Y/48/25/PL

Church Farm House Church Road Yapton BN18 0EP

Removal of tennis court and construction of 1 No self-build single storey energy efficient dwelling.

Drawing Title:
Site Plan

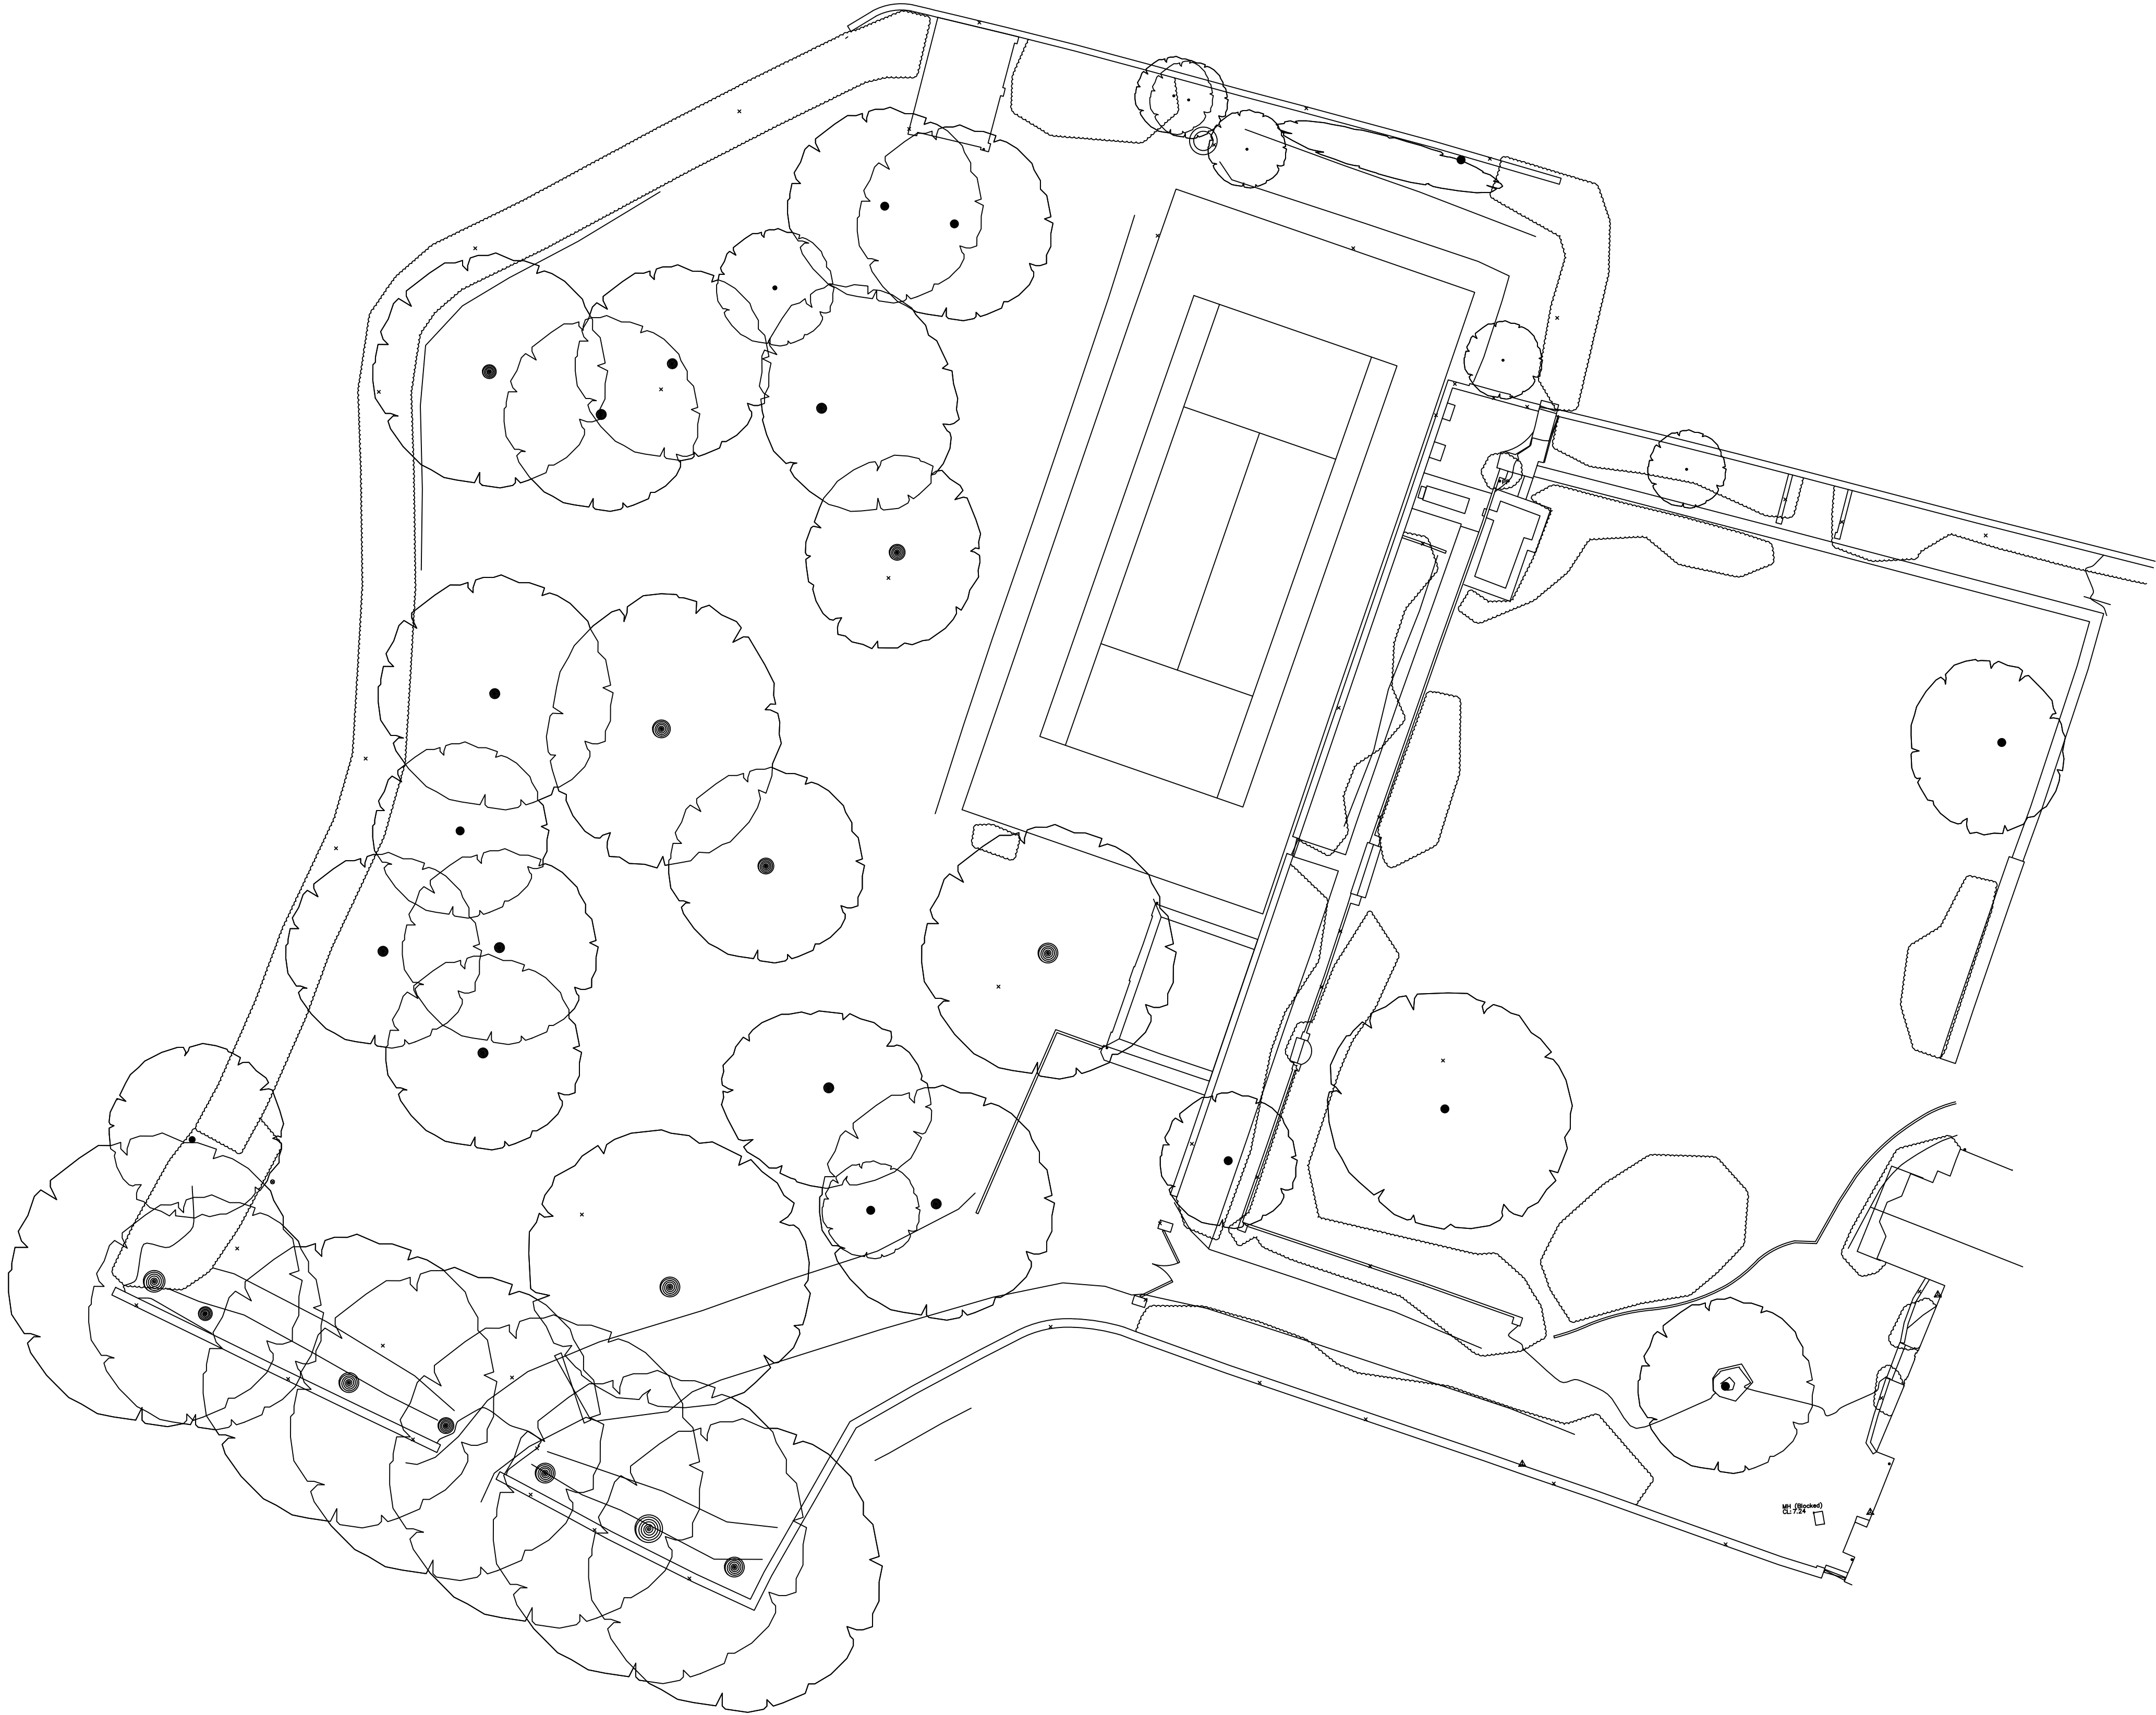
I note his comments regarding the red edge, and I now understand what he refers to. It appears the red edge does not reach the public highway. The Location Plan and Proposed Site Plan provided last week should be updated to include the red edge following the intended access to the public highway. This should have been picked up at validation but considering the likely access route falls within the blue edge, we will accept an amendment in this manner.

Although there are numerous mature trees within the site, their long-term retention cannot be guaranteed. Furthermore, a review of the site location plan reveals that the area within the red line boundary does not include the access route or the land closest to Church Lane. As a result, the definition of the site's southern boundary is unclear, and it is uncertain how the proposed dwelling would be integrated into the surrounding landscape.

Given the semi-rural character of the area and its heritage context, it is recommended that a comprehensive landscaping scheme be submitted as part of the application. This should include additional tree and shrub planting using appropriate native species to help soften the visual impact of the new building when viewed from Church Lane (and also the approach to Church Farm House). It may also be necessary to adjust the red line boundary southwards to accommodate this planting and ensure a coherent landscape strategy.
